**Application for Planning Permission for Works or Extension to a Dwelling**

**Development:** side extension  
**Location:** 1 Stewards Rise Arundel BN18 9ER

I regret that I am unable to accept your documents as a valid application until the following item(s) have been received or resolved :-

Block Plan
Scale: 1:500

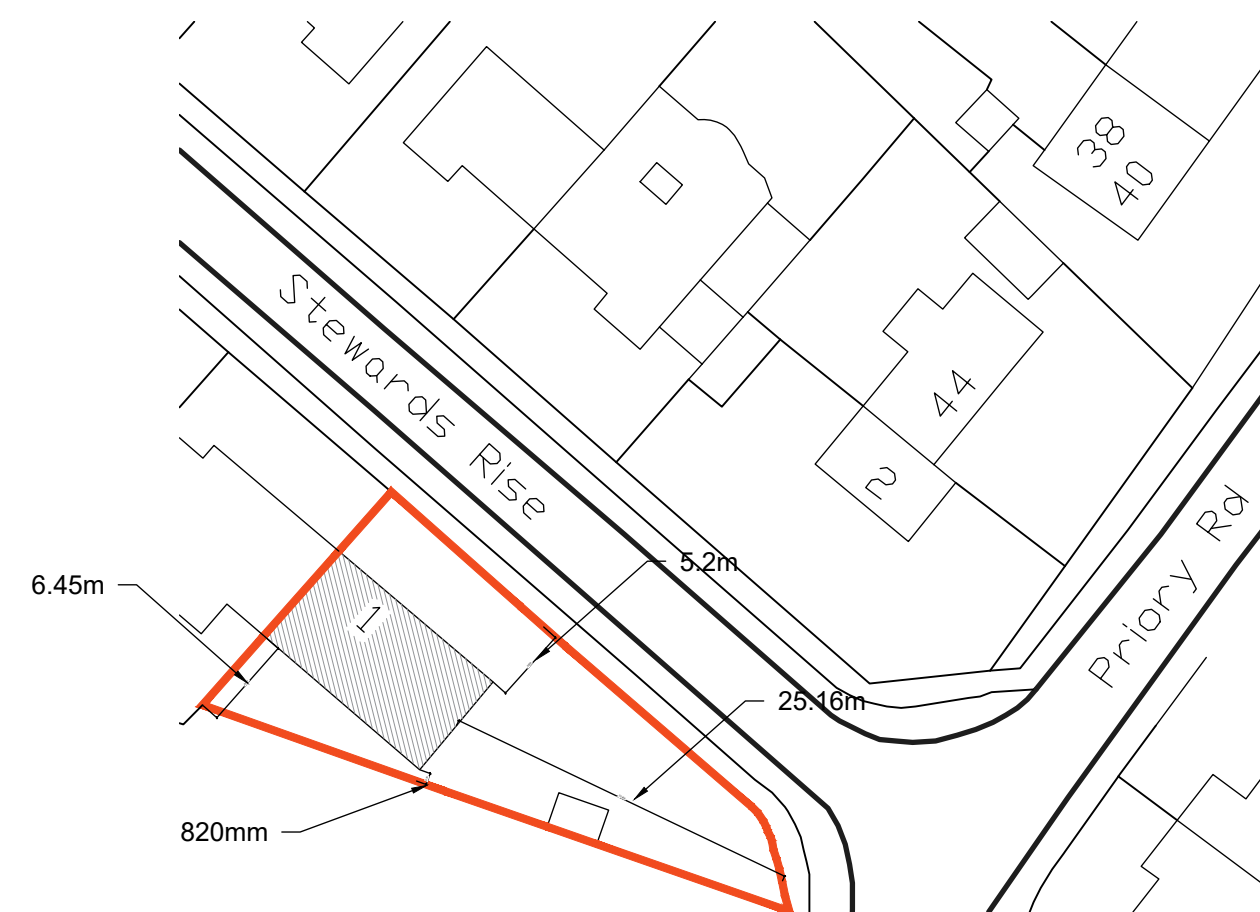
**Block Plan**

You are required to have dimensions from the proposed extension(s) to all site boundaries. Please amend.
